**Ben Eveleigh - Online Submission from Michael Hirsch (object)**

Submission for Job: #4274 MP 10\_0150 - Graythwaite Project Application  
[https://majorprojects.onhiive.com/index.pl?action=view\\_job&id=4274](https://majorprojects.onhiive.com/index.pl?action=view_job&id=4274)

LEGEND

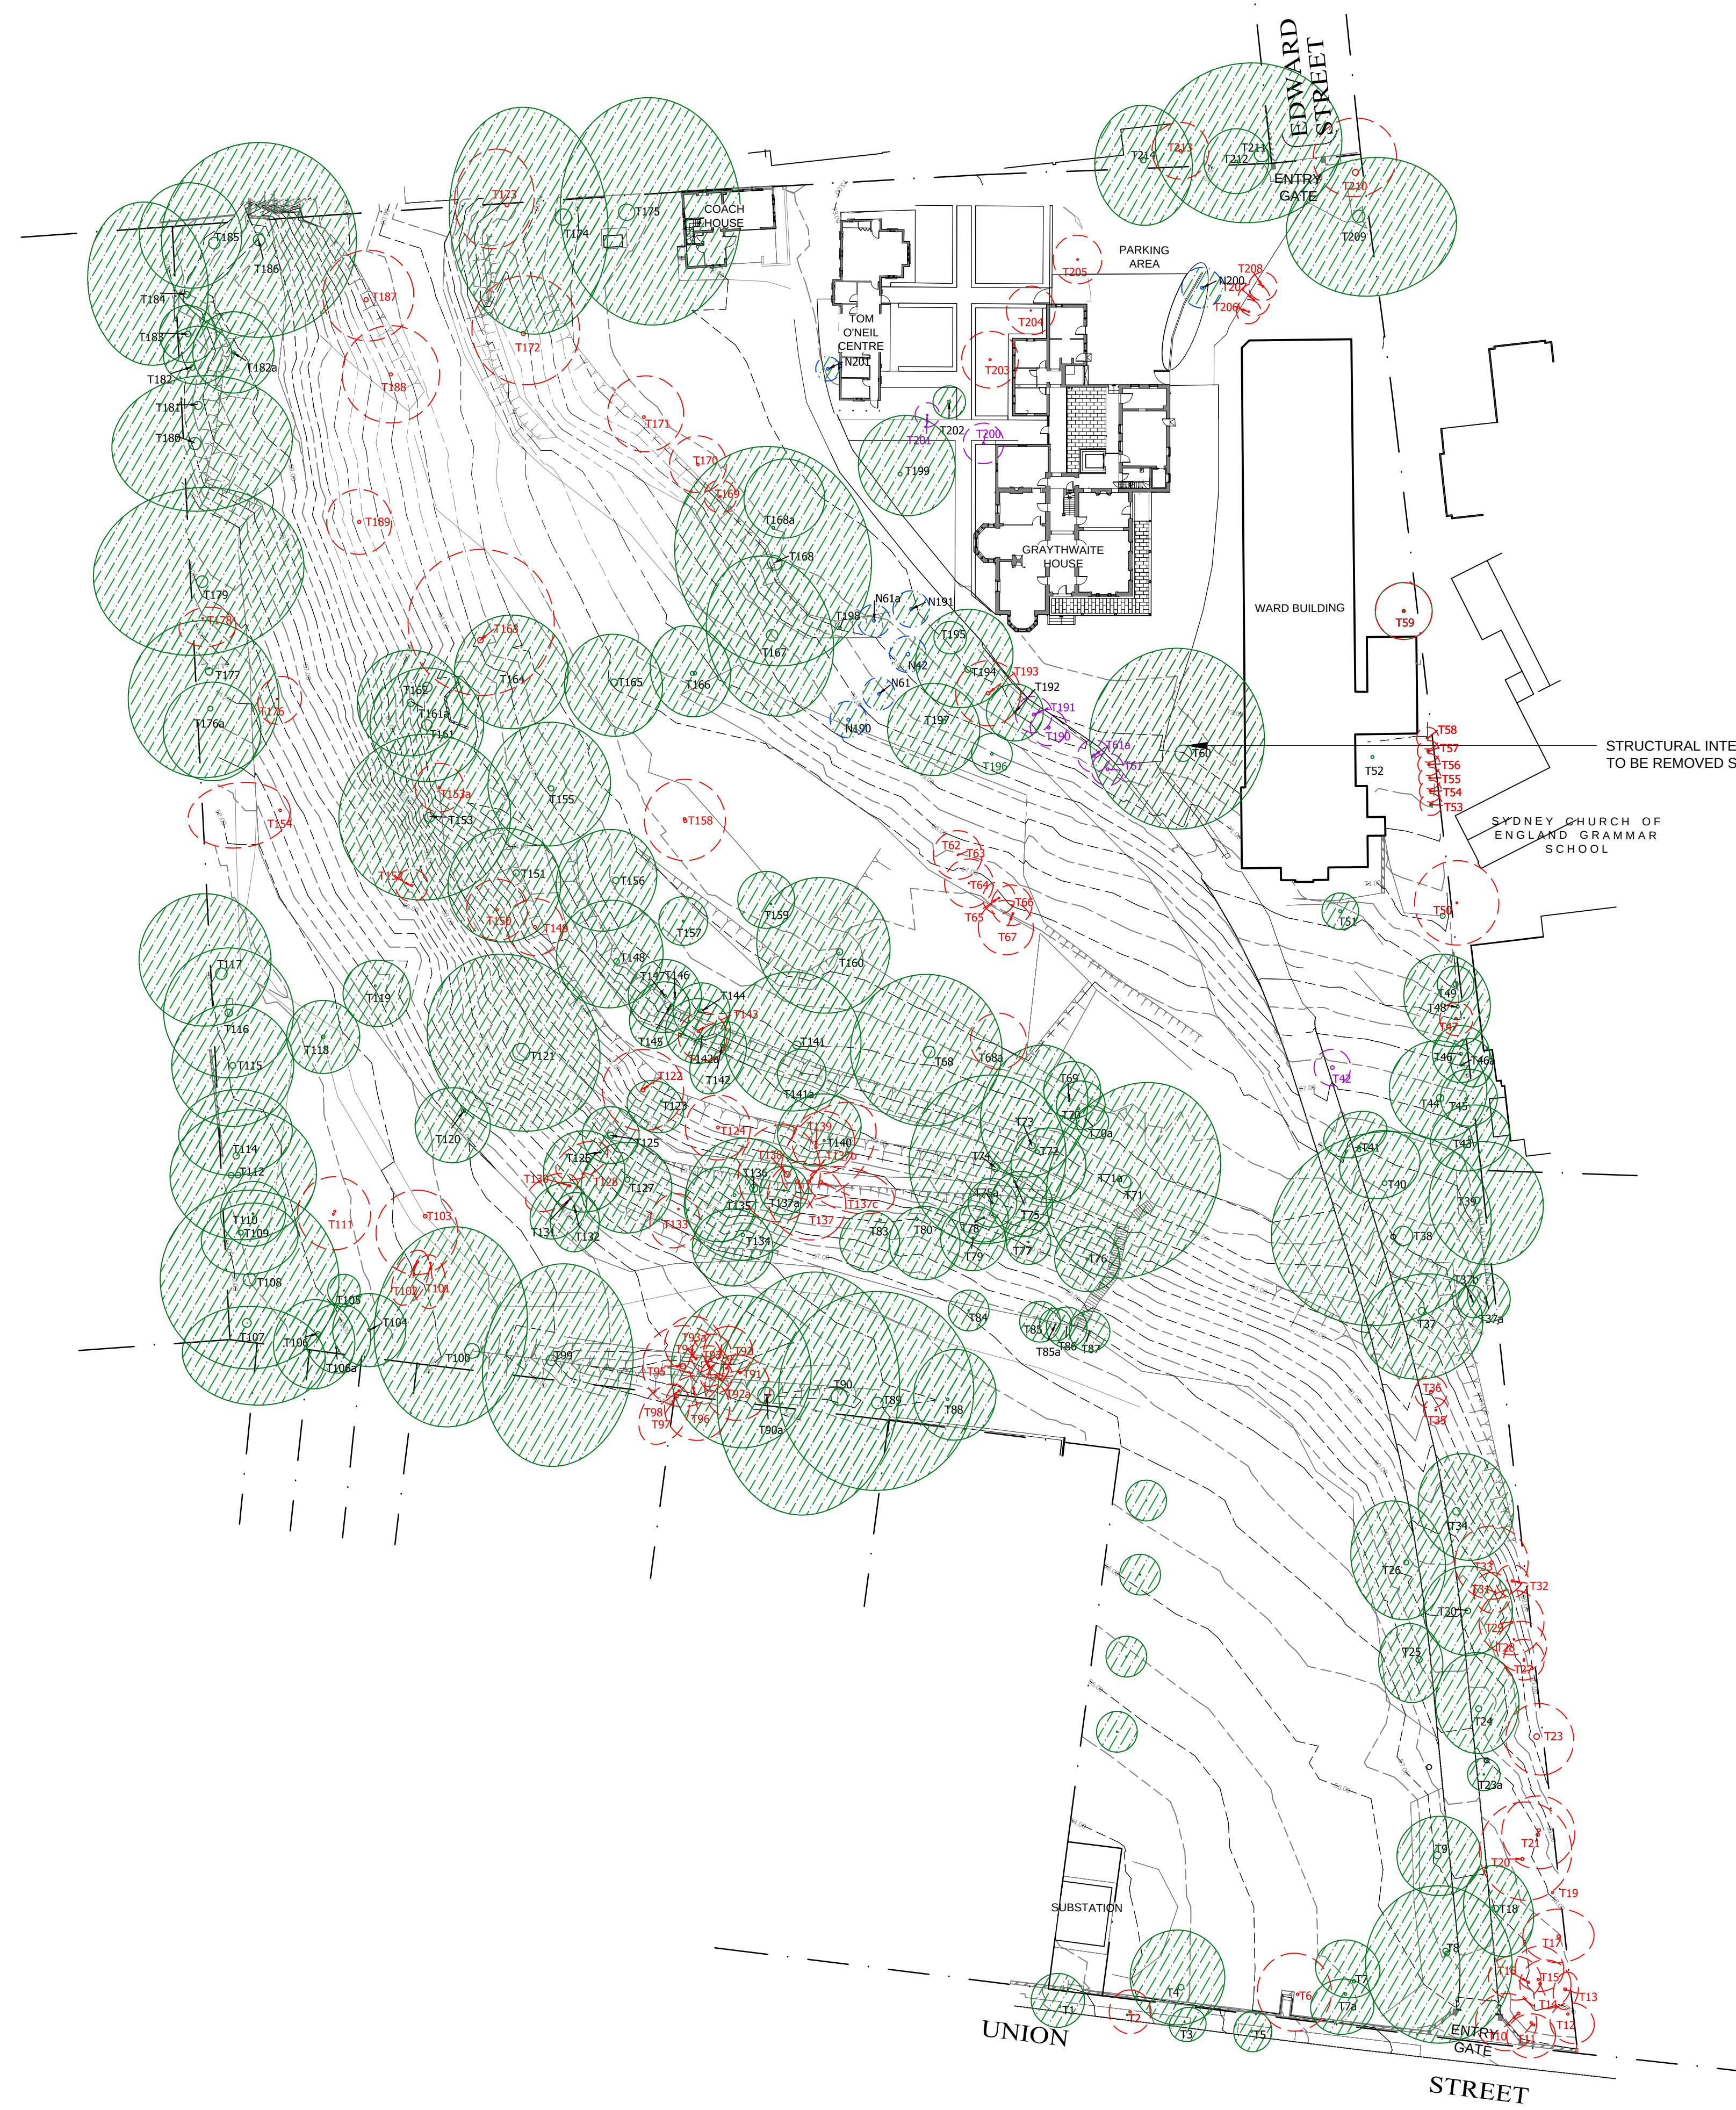
I object to the fact that the applicant is planning to destroy 100 year old trees. Additionally, it appears that the applicant is not honouring the ANZAC memory and tradition, in fact they appear to be dishonouring that memory and tradition. SHAME, SHAME, SHAME.
